88 Preble Street - Curb Ramps and Driveway Details

Thu, Aug 18, 2016 at 3:55 PM

**10**  
C402 CURB RAMP DETAIL AT DRIVEWAY APRON  
NOT TO SCALE

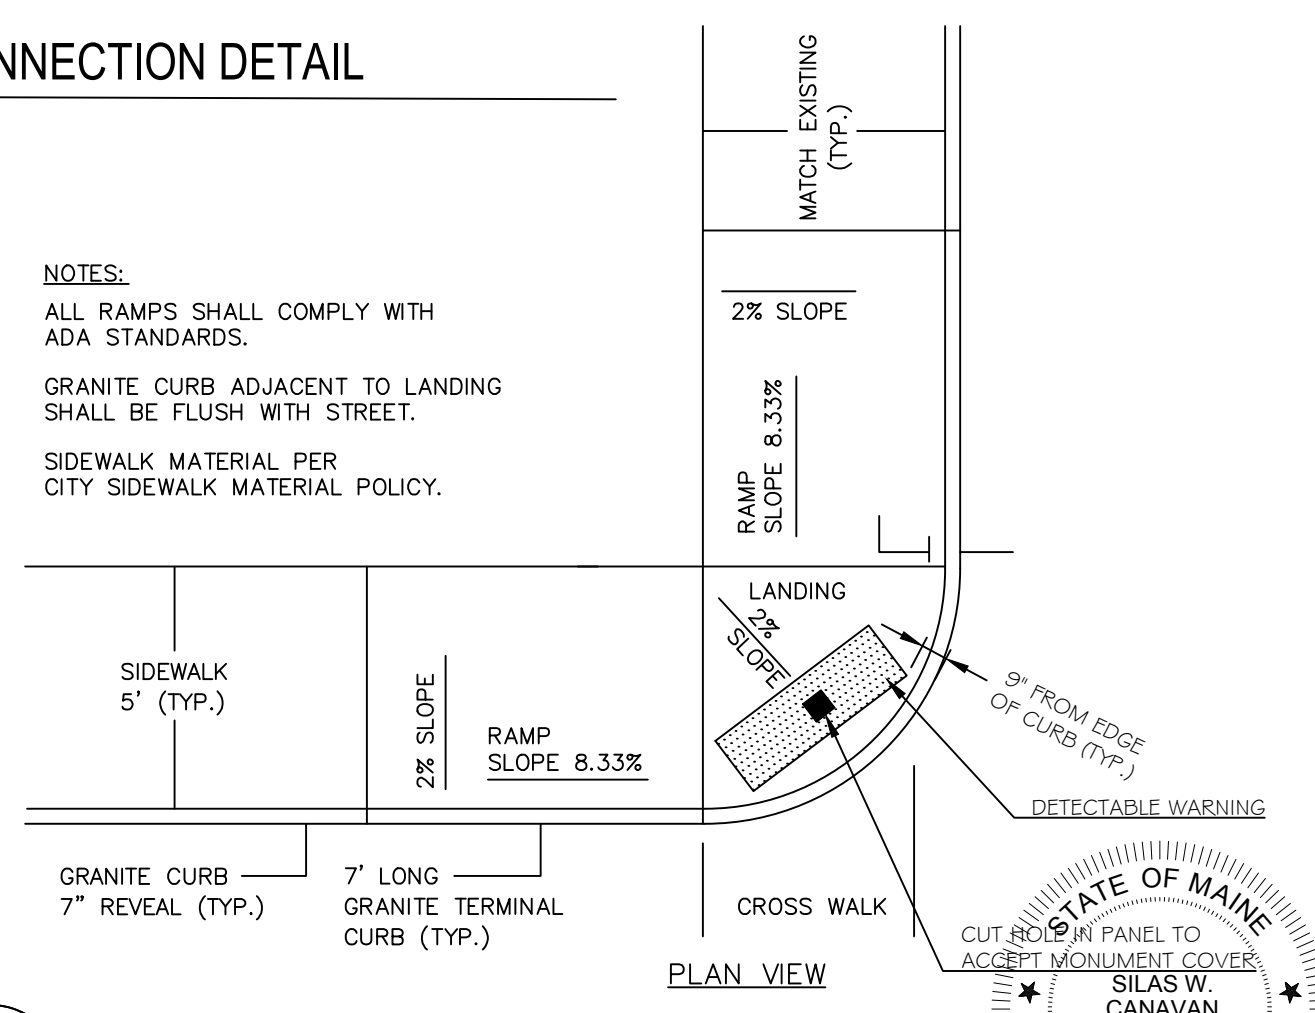
At Alder/Lancaster, I found it difficult to assume we'd want a 2nd ramp over to where the traffic building is now and will later be developed given catch basin and utility pole.

I've tried to configure things as best as I could conceive of them - basically, diagonal/apex ramps at both corners.
